Neighbour Consultee List

Planning Application Reference:	17/01466/F
Location Of Development:	Heyford Park Parcel B2A Camp Road Upper Heyford
Proposed Development Details:	Addition of approximately 310m of metal 'field' style railings painted black (Retrospective)

DRAWING TITLE: **LOTS 79-178 & 265-268 & 299**
FENCE KEY PLAN

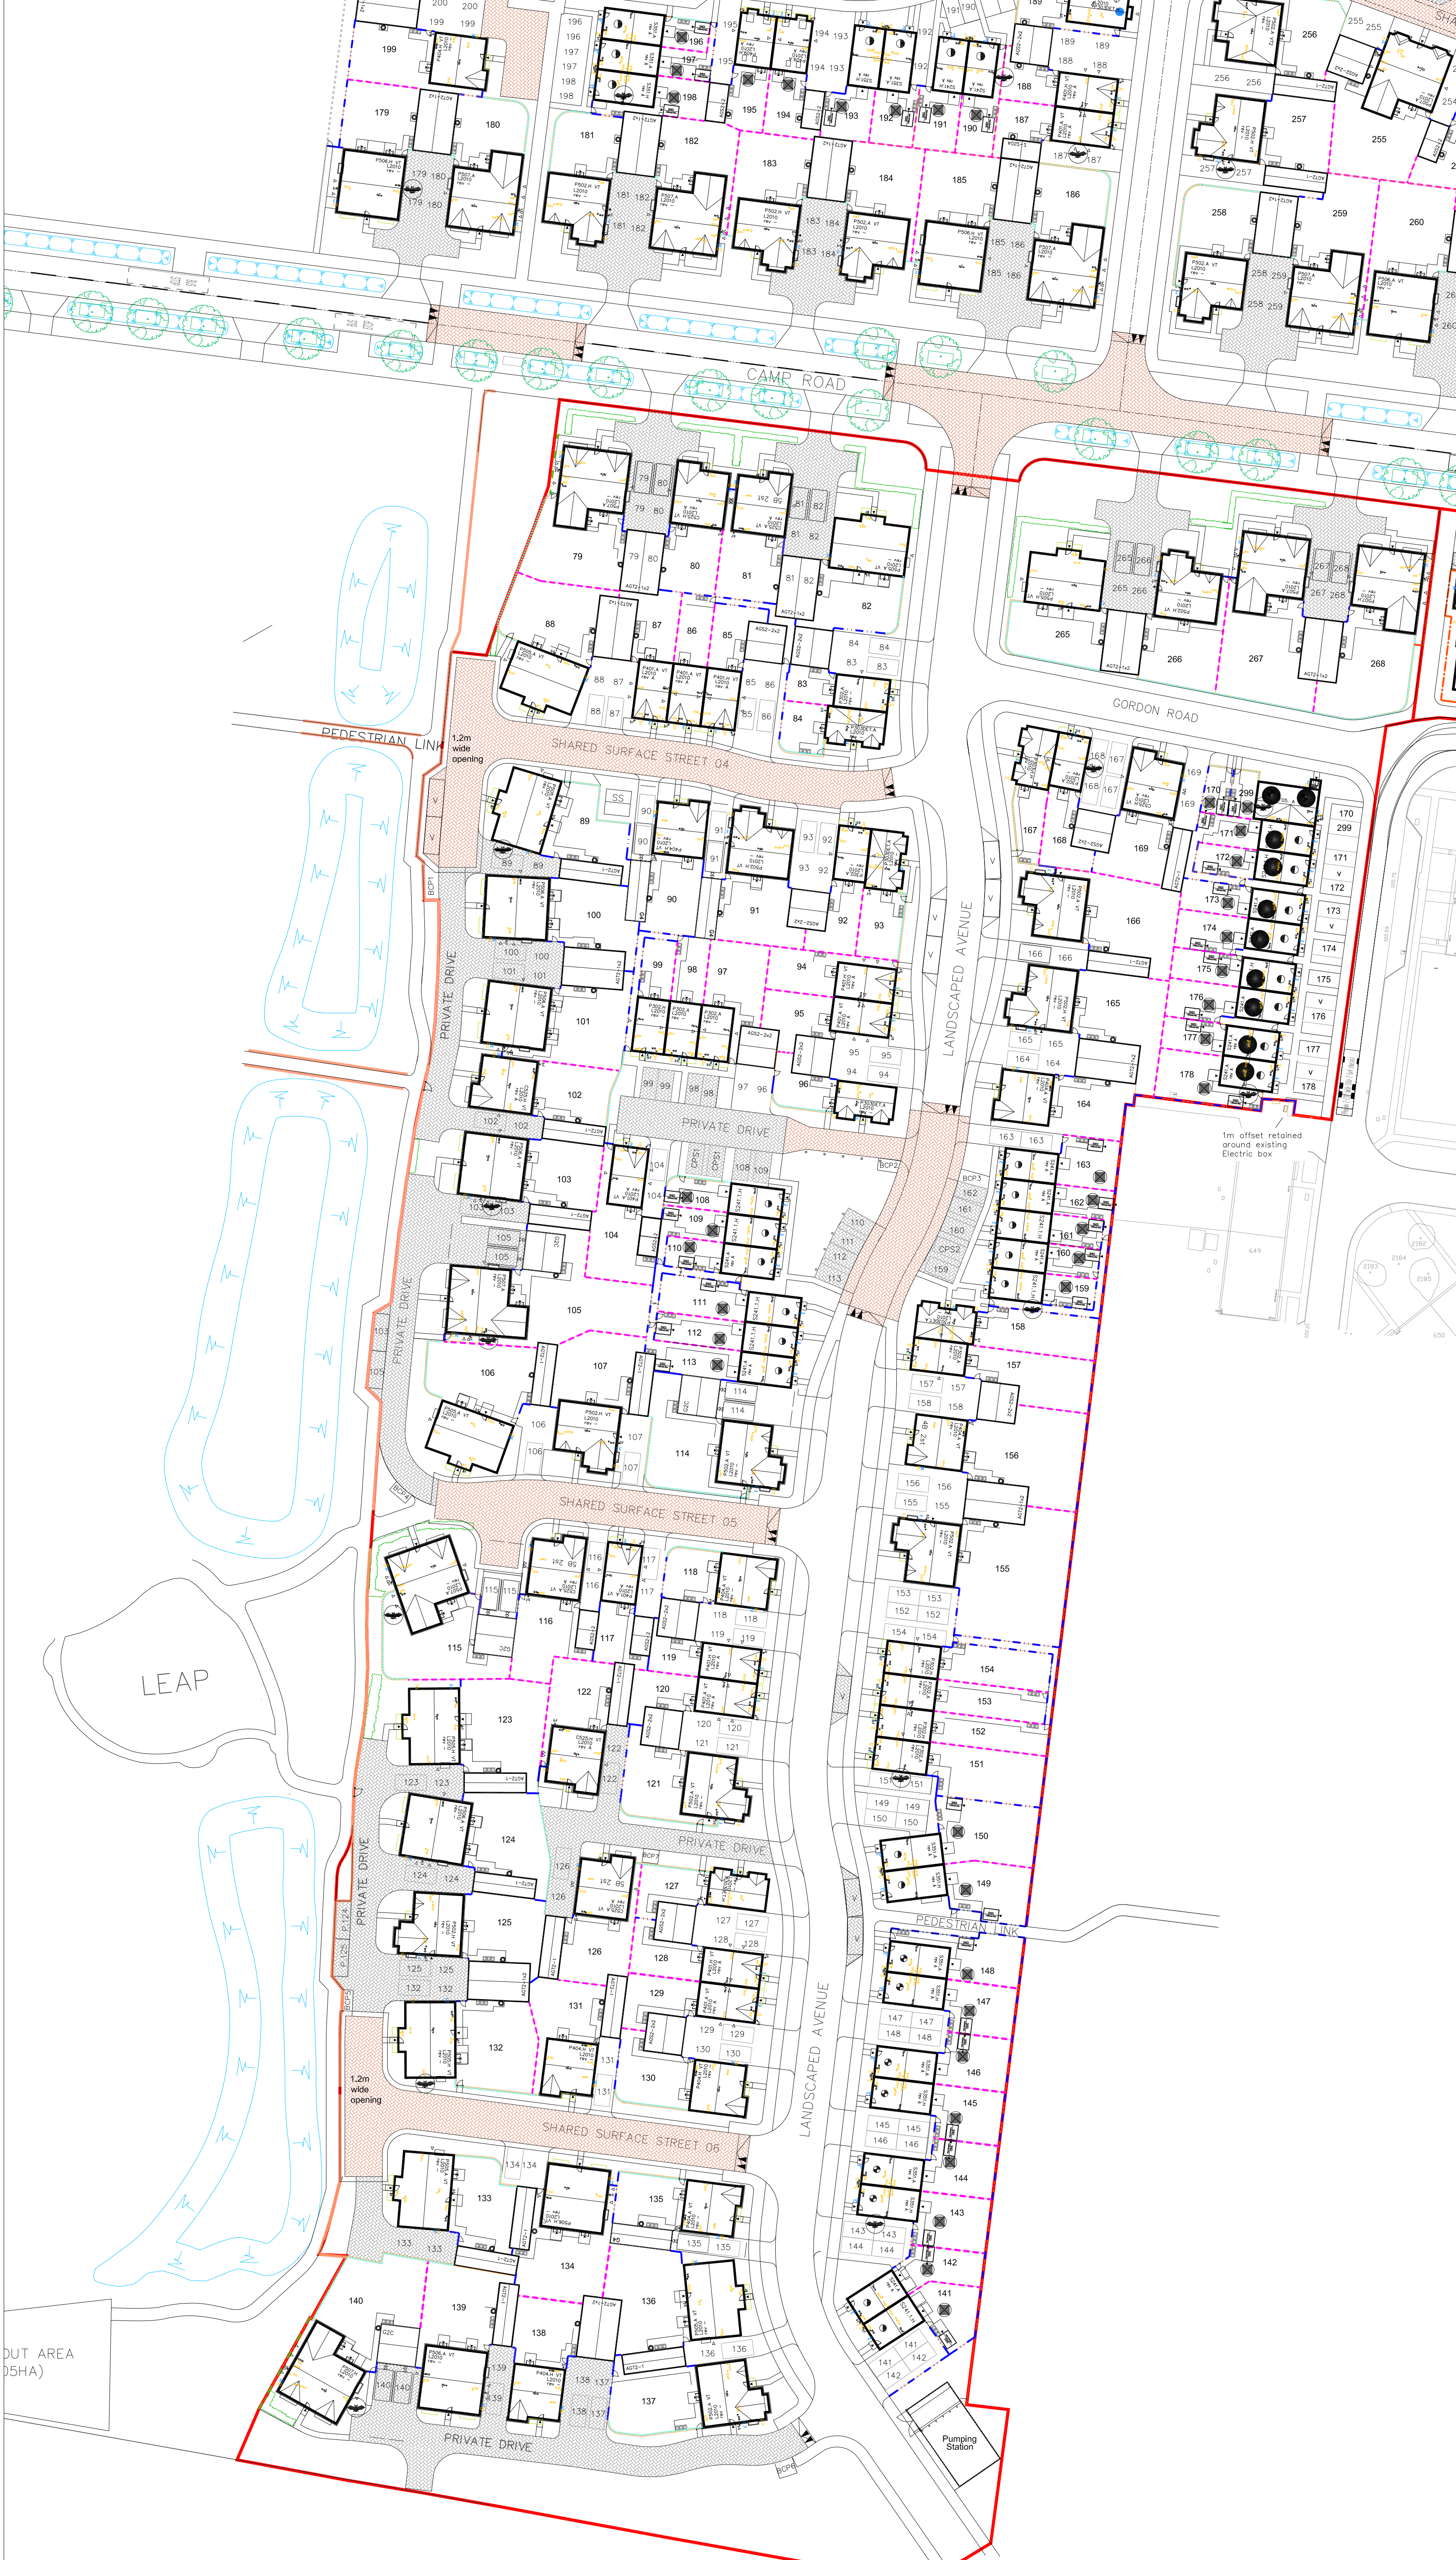
Whilst the planning documents are inconsistent in their depiction of the fence, I assume that the fence supposedly serves two purposes: Firstly, to separate the two east-west "pedestrian link" footpaths from the swales; and secondly, to separate a footpath from shared driveways (part public, part private).

The second purpose seems not to have any genuine "safety concern" and is only really to separate a public footpath from a shared driveway or surface street. I would argue that the fence creates more of a safety issue as it restricts the usable width of the footpath so a young child on a bike is more likely to fall into the fence rather swerve temporarily onto the driveway. If fences are not required outside the school on Camp Road then why would it be deemed a "safety concern" next to a driveway? Why was this not deemed a concern during the original planning process? Furthermore, in no way does the fence separate the main footpath from the swales so this cannot be the "safety concern". No fencing exists on the Broad Way side of the swale which-although it does not have public footpath-is used extensively by pedestrians and young children.

The proposed fence separates the path from open areas creating isolated pockets of green where there should be large open areas such as at the northern end of the fence where it meets Camp Road.

Without prejudice, if this fence is *really* required to keep children safe, it will not work. Small children can easily pass through the railings but adults caring for them cannot. This itself presents dangerous scenarios.
